**Response to
Department for Business, Energy and Industrial Strategy
Request for Further Information issued on 31 March 2022
from the Royal Society for the Protection of Birds
and Suffolk Wildlife Trust**

**Application by NNB Generation Company (SZC) Limited for an Order
Granting Development Consent for
The Sizewell C Project**

**Planning Inspectorate Ref: EN010012
The RSPB PINs Registration Identification Ref: 20026628
Suffolk Wildlife Trust Registration Identification Ref: 20026359**

SECTION @ B - B - SEA DEFENCE
SCALE 1:250

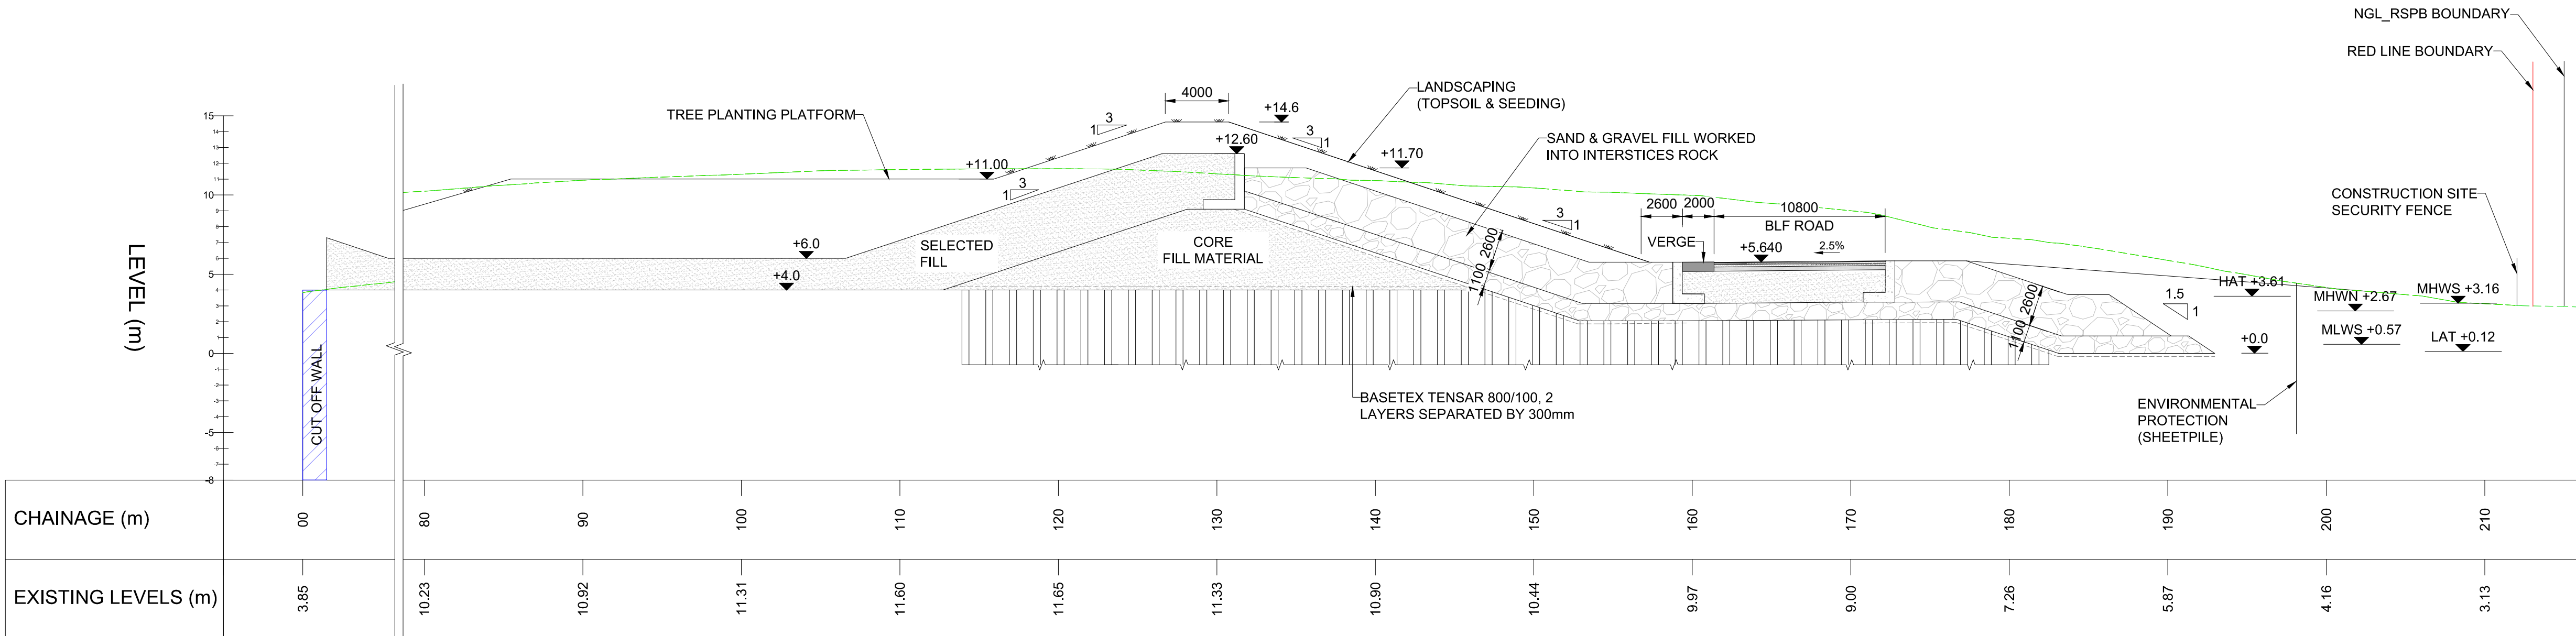
- 1.1.1. the approach to particle size for the Soft Coastal Defence Feature (SCDF) does not appear to be confirmed and there remains a risk that further technical modelling could lead to a decision for coarser material required for engineering function that is not compatible with the ecological function of the neighbouring Minsmere to Walberswick Heaths and Marshes SAC³ (particularly with respect to the annual vegetation of drift lines and the perennial vegetation of stony banks interest features) and Minsmere - Walberswick SPA⁴ (particularly with respect to nesting little tern) and Ramsar site⁵ (particularly with respect to shingle beaches and nesting little tern) (and their underpinning SSSIs)(the protected sites), therefore our concerns about the lasting impacts to those sites remain;

- 1.3. We also welcome that the subsequent paragraph has been amended to reflect the vegetation feature remains *in situ* but we continue to contest the confident assertion that the provision of sediments to the SCDF is likely to provide a benefit to the vegetation communities on the Minsmere frontage (as per section 11.5 of our Examination submission in [REP8-173](#)). This concern also remains due to the approach to particle sizes which retains some uncertainty due to section 2.4 which states that

1.6. This also does not resolve our concerns that the SCDF will not reflect the natural beach particle size required to support the interest features of the protected sites and follows on from our previous concern following Issue Specific Hearing 11 where the Applicant proposed that if material size was fixed it could be problematic to engineering function and it would be better to discharge as a condition in due course (see section 5.14 [REP8-173](#)⁷). We remain concerned that the technical solutions for the SCDF will ultimately be determined by engineering requirements rather than ecological sensitivities. As per our Examination Submissions (see sections 3.108 – 3.122 [REP2-506](#)⁸), the vegetation communities for which the shingle beach is designated and therefore should be protected, require a dynamic environment and are not necessarily supported by ‘increased stability’. In terms of ecological function, the SCDF should retain a sand component that is consistent with the current proportion of sand in the existing beach profiles. The presence of fine particles, including sand, is an important component to enable the shingle beach to support the vegetated conservation interest features of the protected sites. Walmsley and Davy (2001)⁹ reporting on their studies of vegetation establishment at Sizewell following the construction of Sizewell B identified the need for 10 – 20% sand content to enable vegetation to establish.

1.8. The Applicant has failed to present any tangible evidence to support the apparent commitment to retaining the native particle size distribution within and adjacent to the protected sites that we believe is essential to ensuring no adverse effects on integrity to the Minsmere – Walberswick SAC as set out in our previous submissions. We therefore believe this issue has not been satisfactorily resolved and that there is a high level of risk that the technical conclusion in engineering terms will lead to a solution that results in adverse effects on the integrity of the protected sites.

- 1.24. Ultimately, our main concern is the ambiguity over the technical detail with the SCDF and the mechanisms to how this will be resolved. It appears that the most suitable engineering solution could be approved without taking sufficient account of the impacts on the adjacent habitats. We also remain concerned that should damage to the adjacent habitats within protected sites occur, there are no examples of suitable mitigation strategies that could be implemented.
